Site Plan Drawing_V2.pdf Markup Summary

Subject: Group
Page Label: 1
Author: Sophie Kiepe
Date: 4/13/2021 2:08:16 PM
Status:
Color: ■
Layer:
Space:

A Site Plan
 SCALE: 1" = 20'-0"

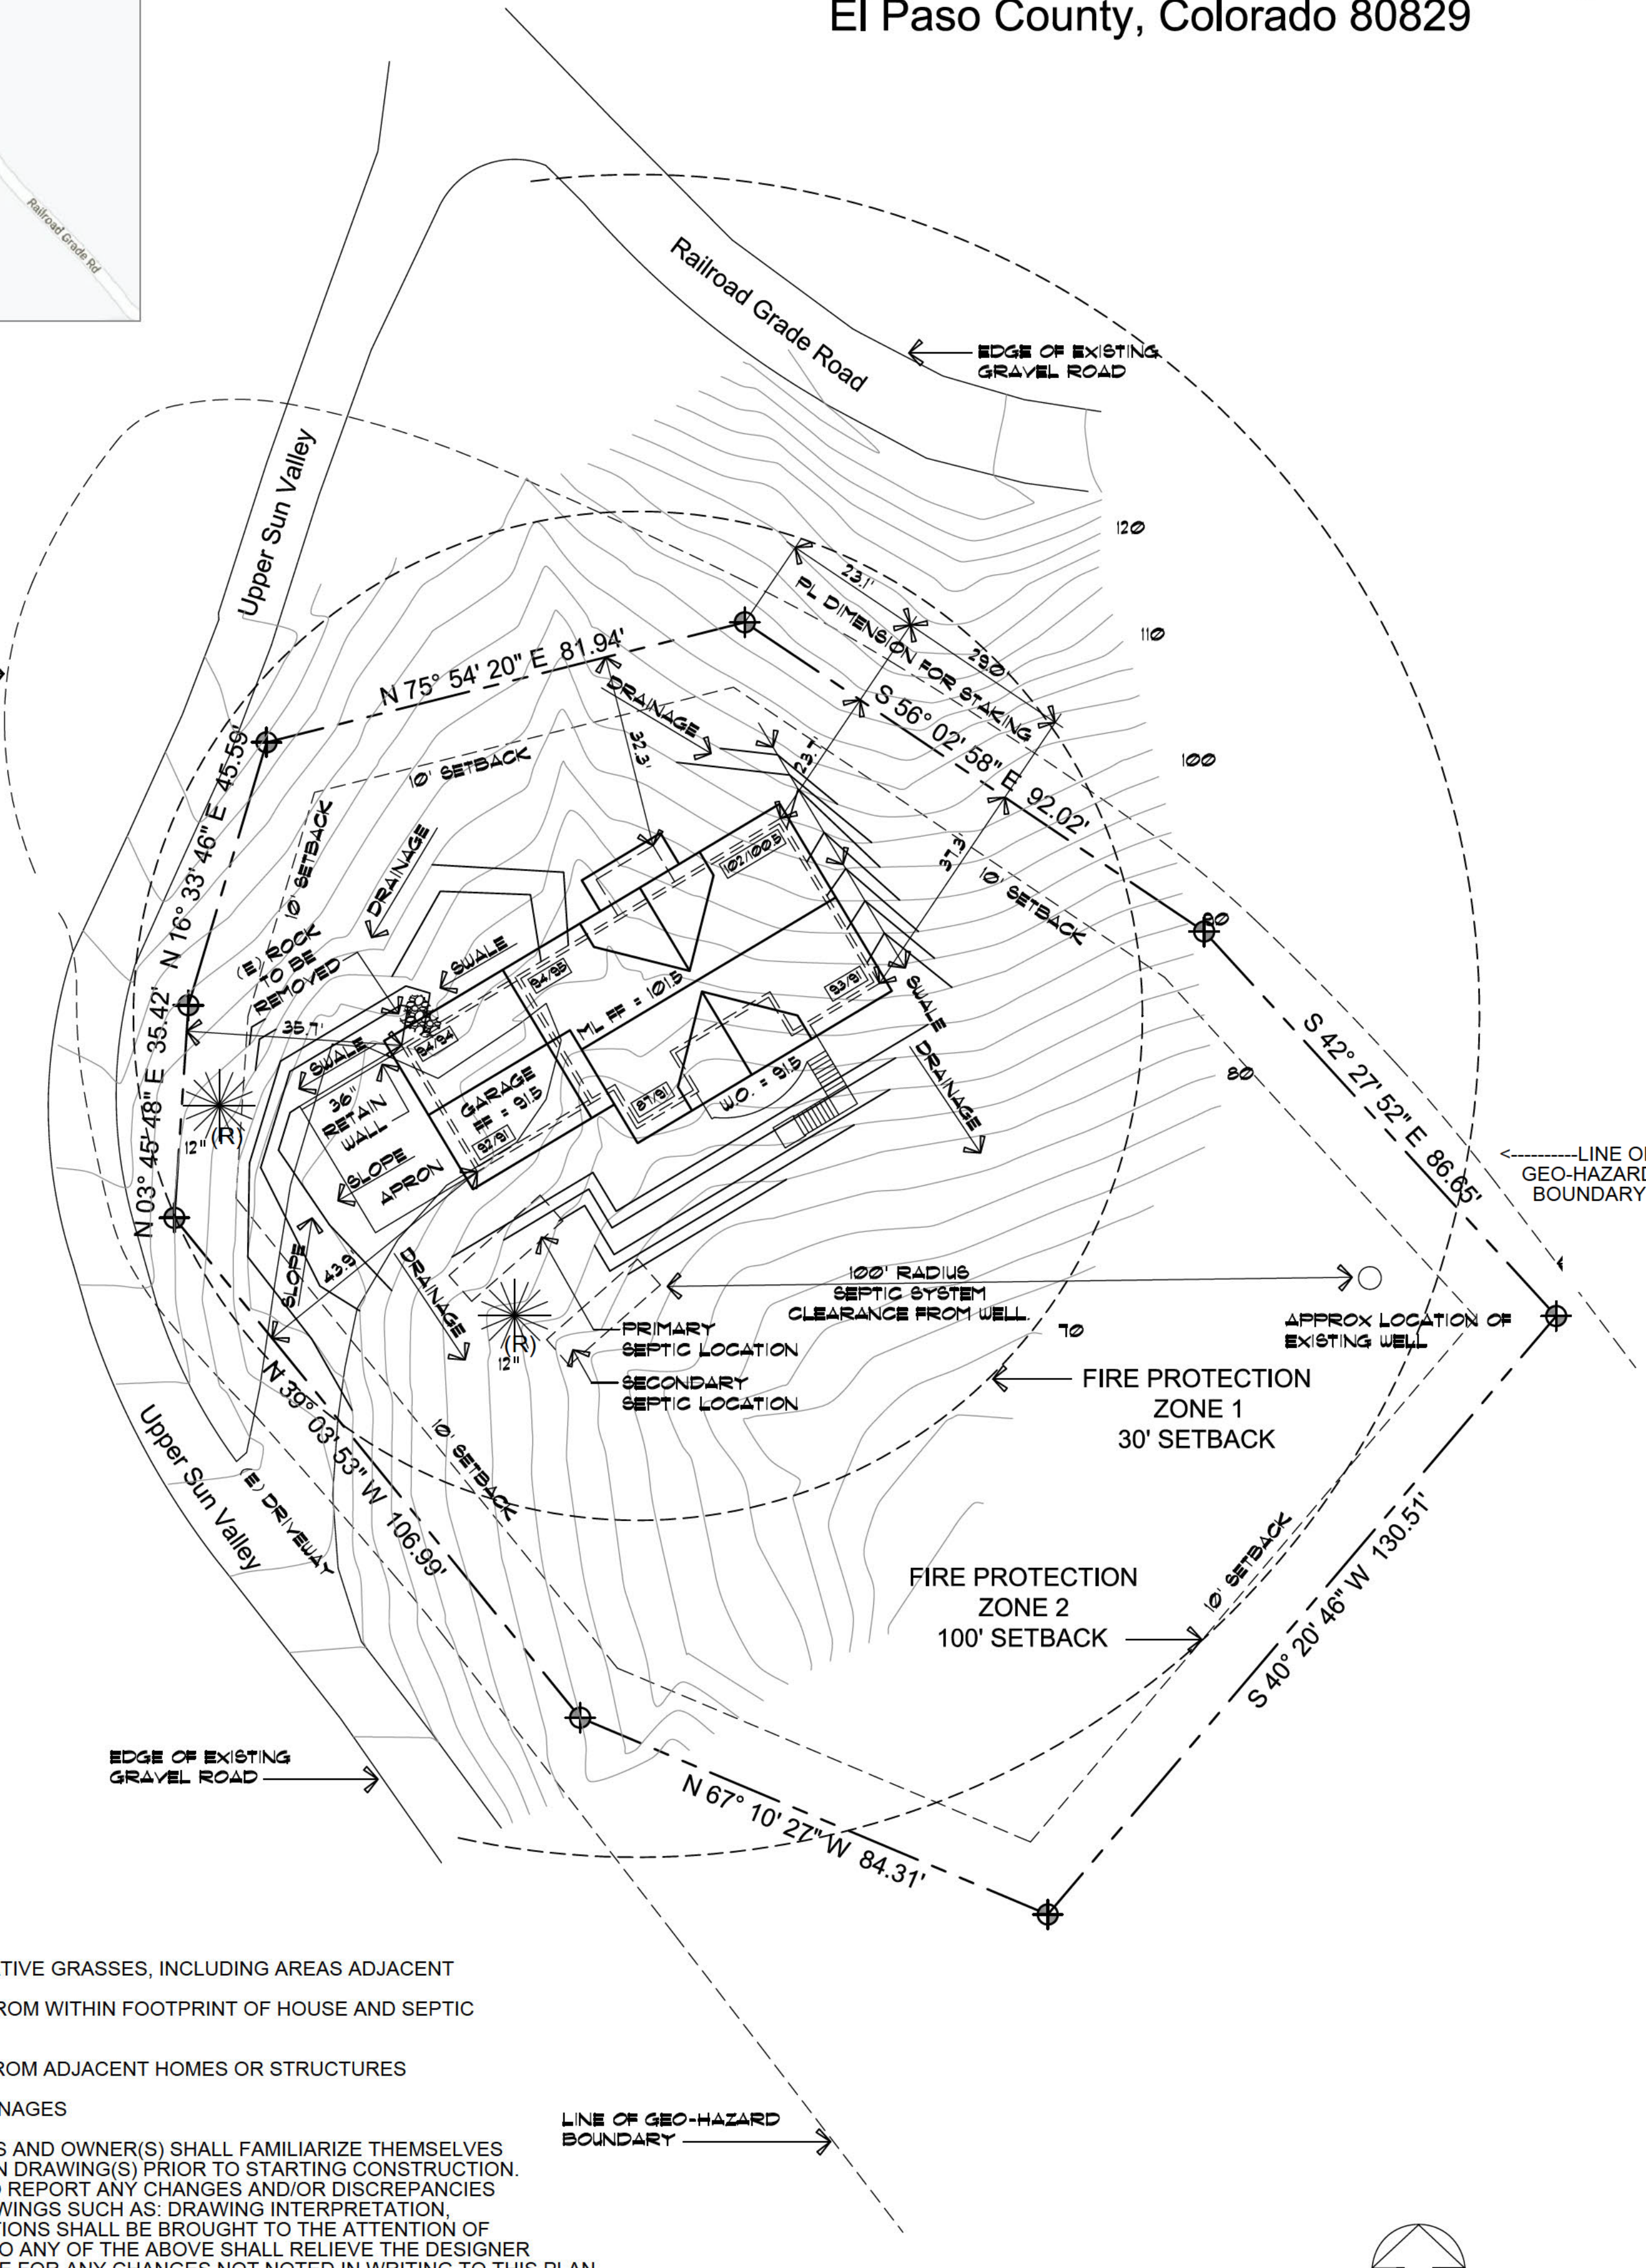
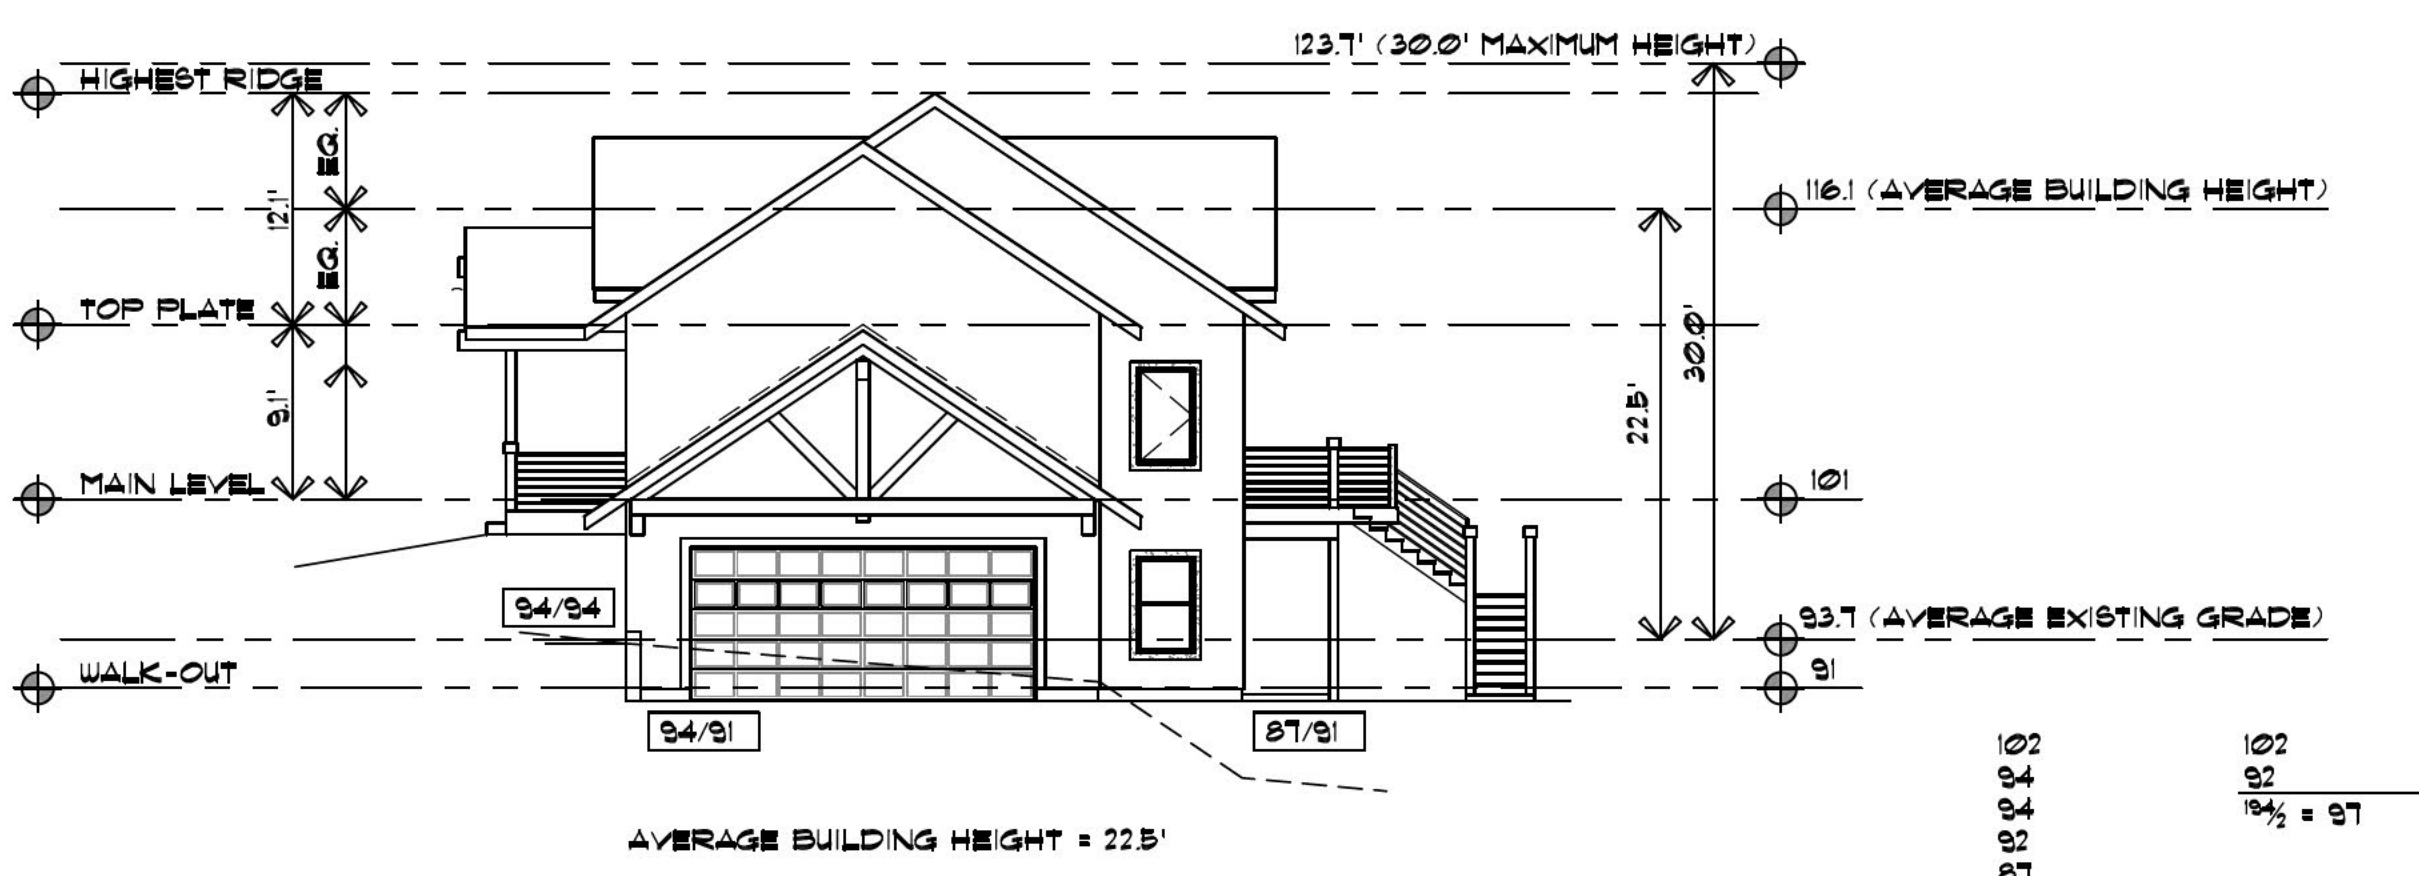
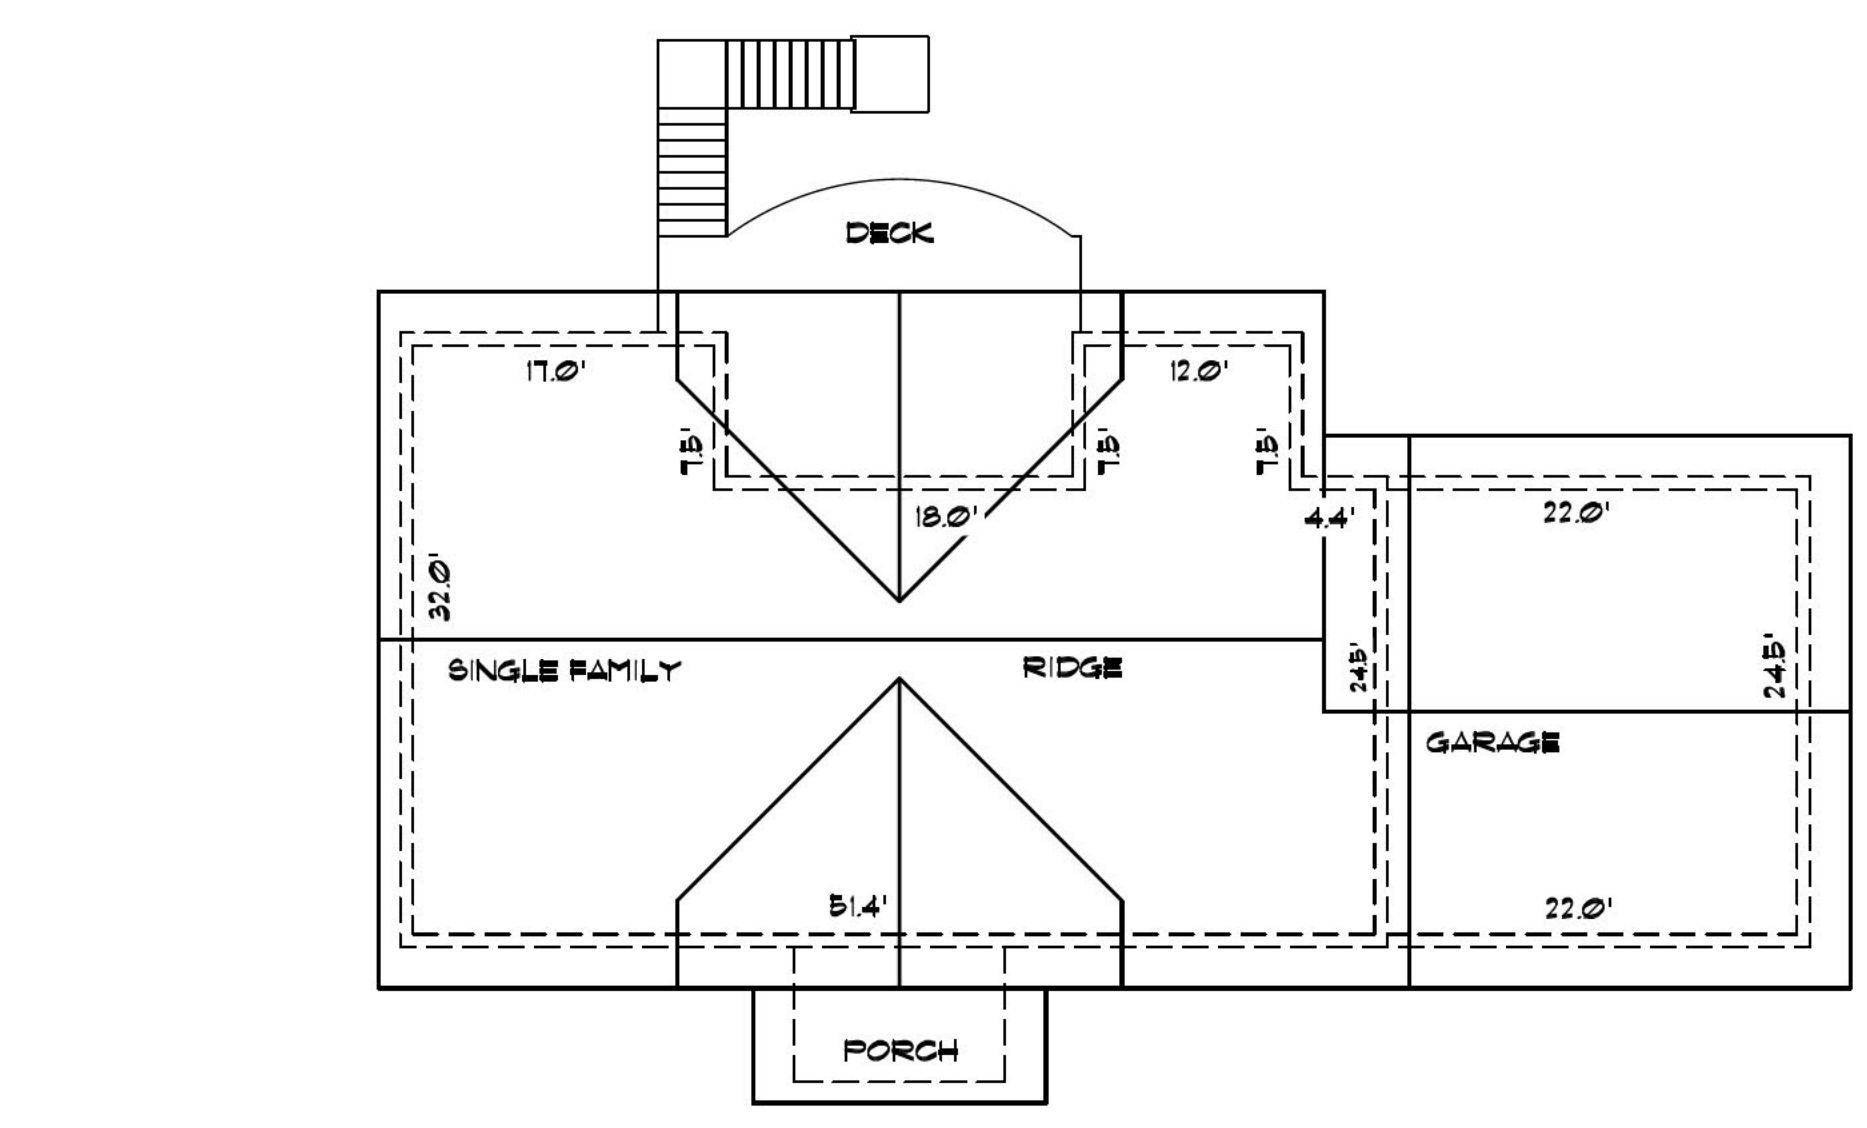
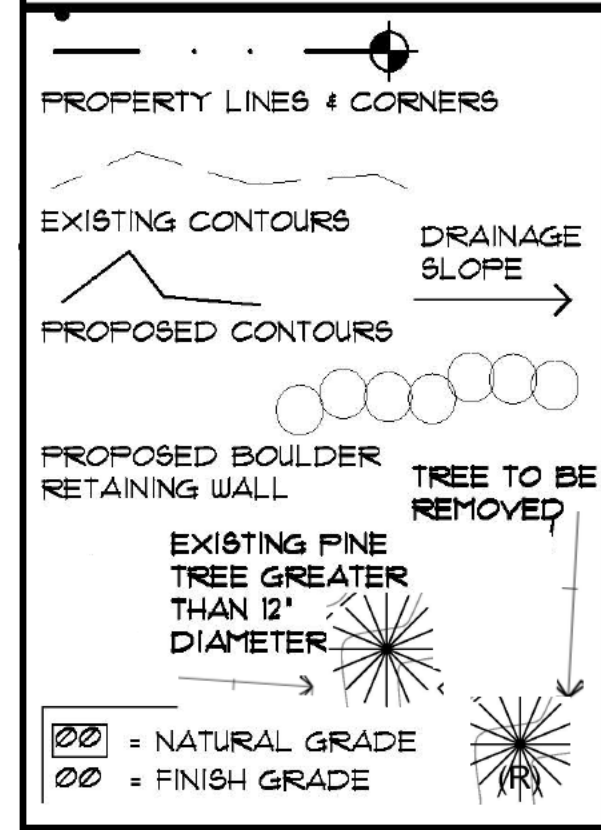
[REPEAT COMMENT]:

Landscaping/ information is required per
Development Regulations:

Specifically:

1. please show the required landscaping information, including showing trees on legend, show any existing trees to be removed vs. to stay, and revegetation plan or note regarding same (see below).

You can add to your note that final landscaping to be determined / done by the contractor/owner.

Also, please add the following note, standard for CP site plans:
